RE: REVISED DRAINAGE PLAN FOR PHILLIPS 66 @ HANOVER & COORS (J11-D30)  
REVISION DATED 3/30/98

RE: CONCEPTUAL GRADING & DRAINAGE PLAN FOR PHILLIPS 66 @ HANOVER  
& COORS (J11-D30) ENGINEER'S STAMP DATED 10/23/97

**Re: Phillips 66 Hanover and Coors(J11-D30) Grading and Drainage Plan for Building Permit**

RE: REVISED DRAINAGE PLAN FOR PHILLIPS 66 - HANOVER & COORS (J11-D30)  
ENGINEER'S STAMP DATED 5/4/98

PHILLIPS 66 - HANOVER AND COORS
CONCEPTUAL GRADING AND DRAINAGE PLAN

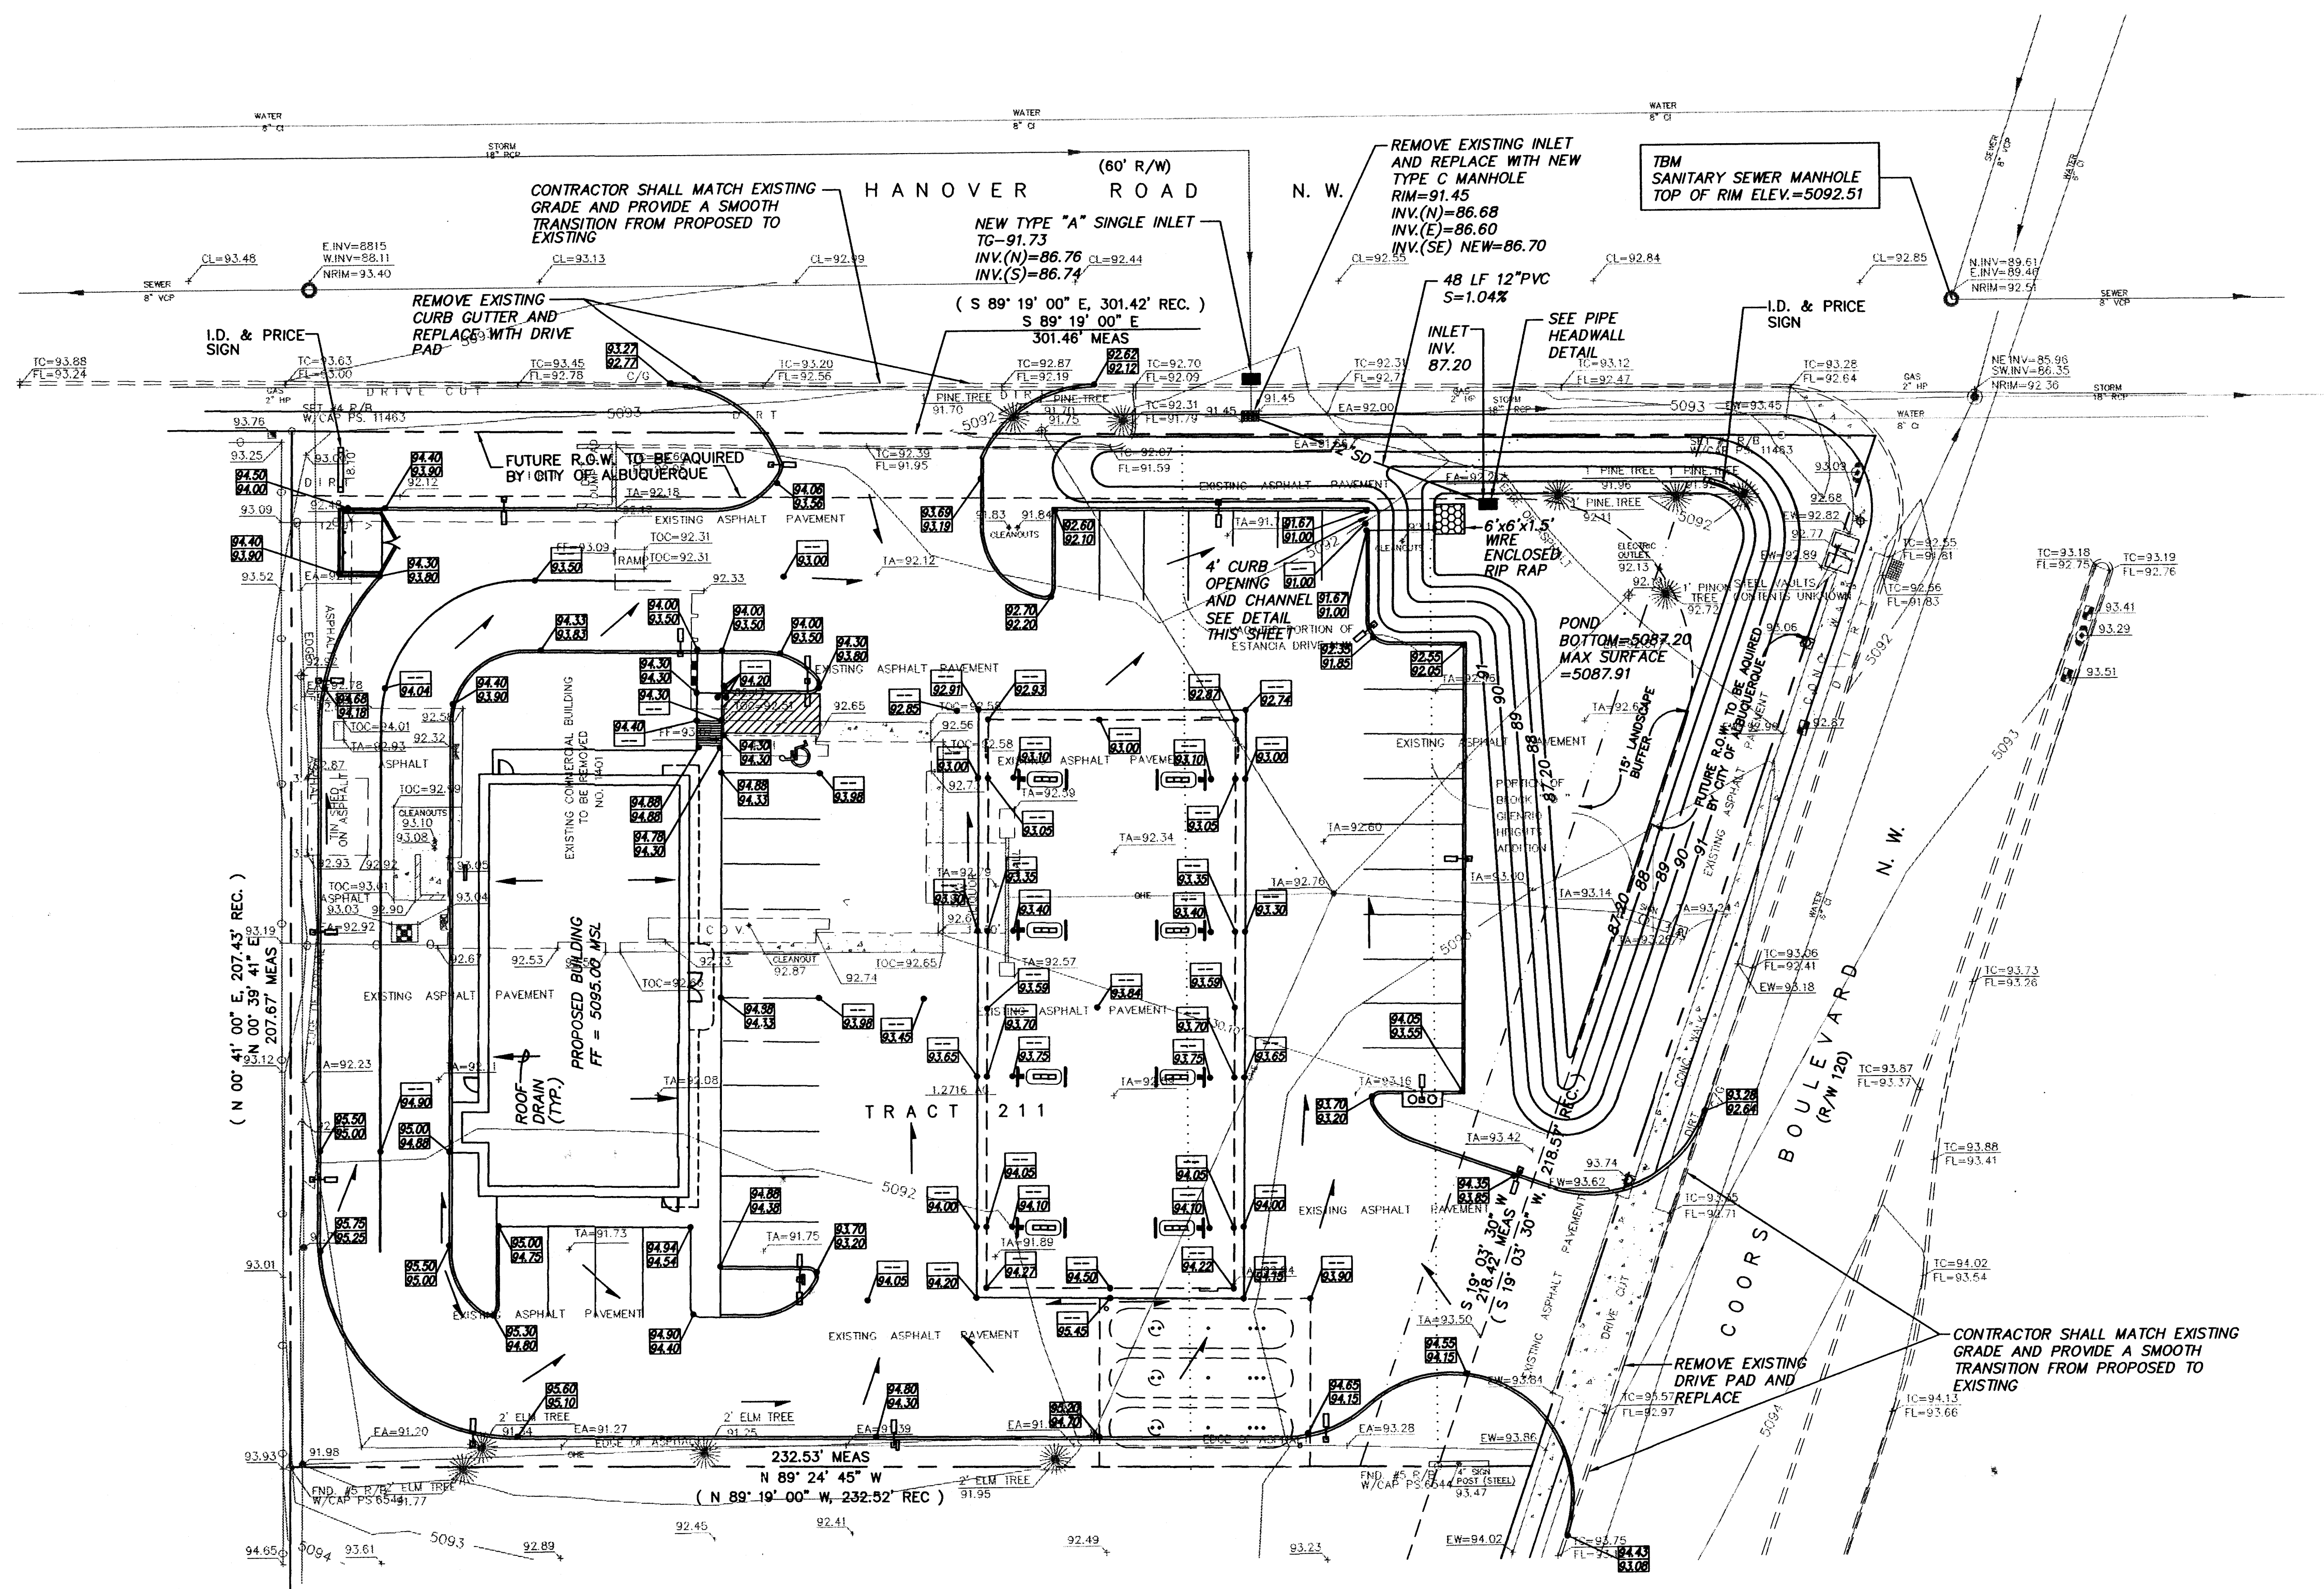
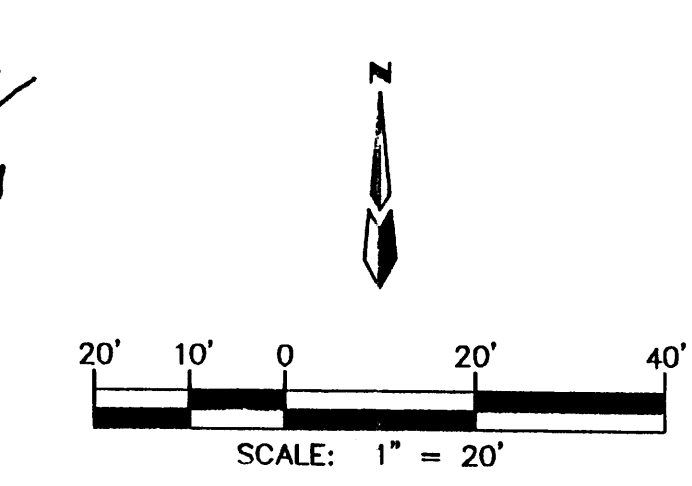
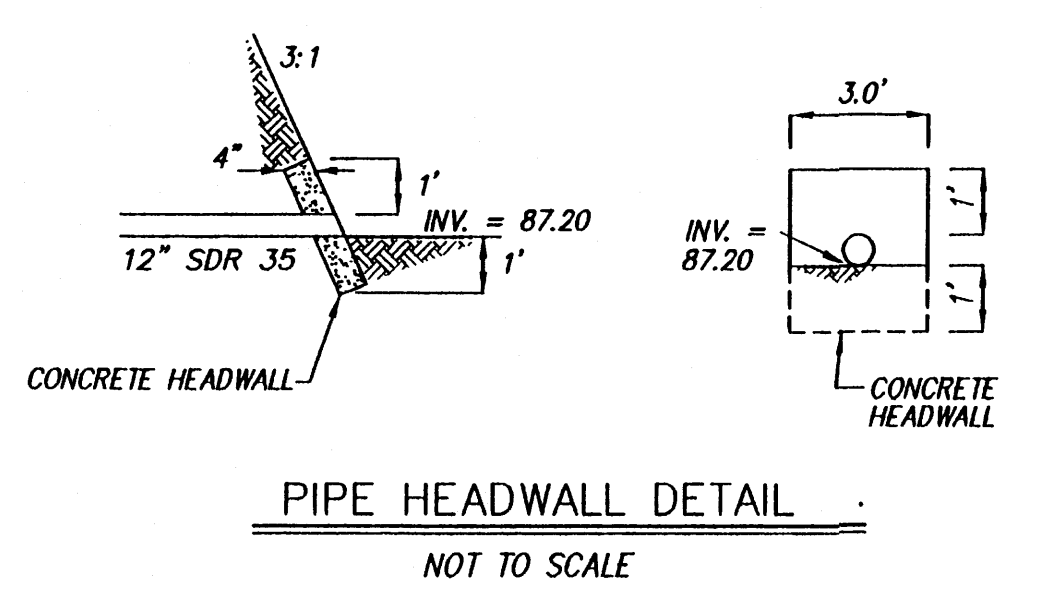
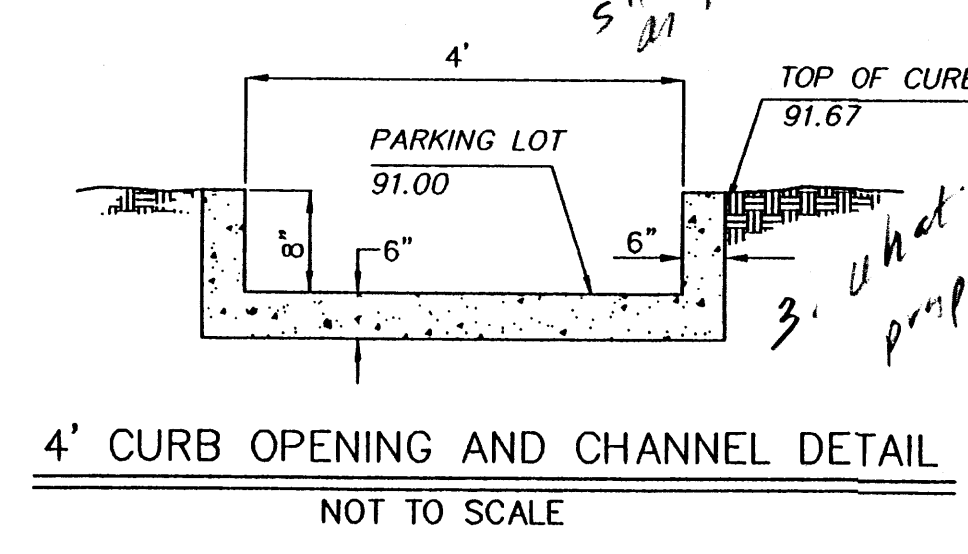
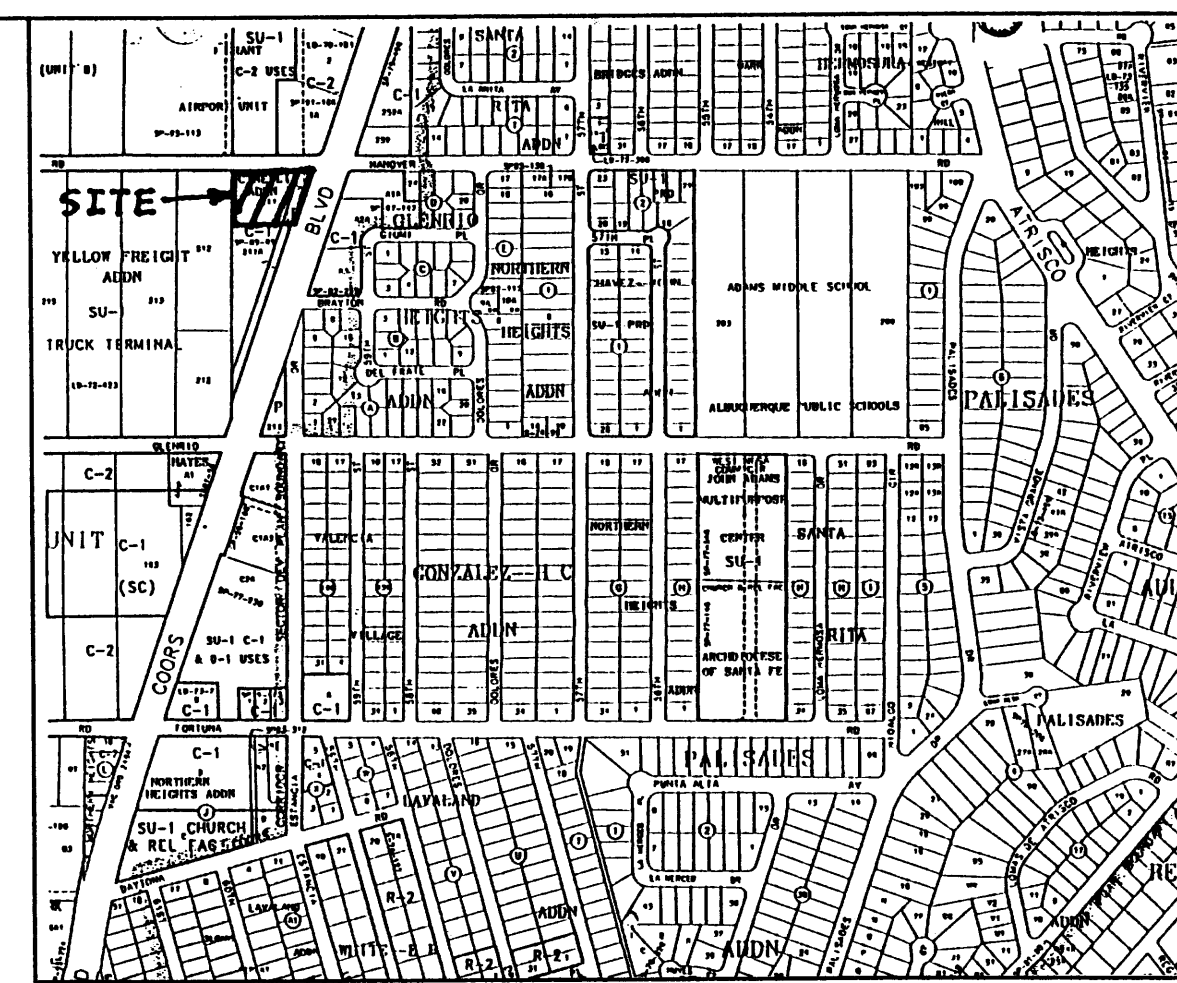
Must address R/W within the  
pending area

1. Submit a copy to Loren Mainz at City Hall 3rd. floor for his review for EPA standards.
2. Your report indicates that the pond is to be located on the Northwest side of the site and the plan drawing shows it on the Northeast.
3. What type of sediment control to you propose within the ponding area?

- Comment #1- A copy of this revised plan has been submitted to Loren Meinz.
- Comment #2- The description as described on the drainage report was a mislabel.
- Comment #3- A 12" mat of smooth river rock has been added to the pond bottom for sediment control.
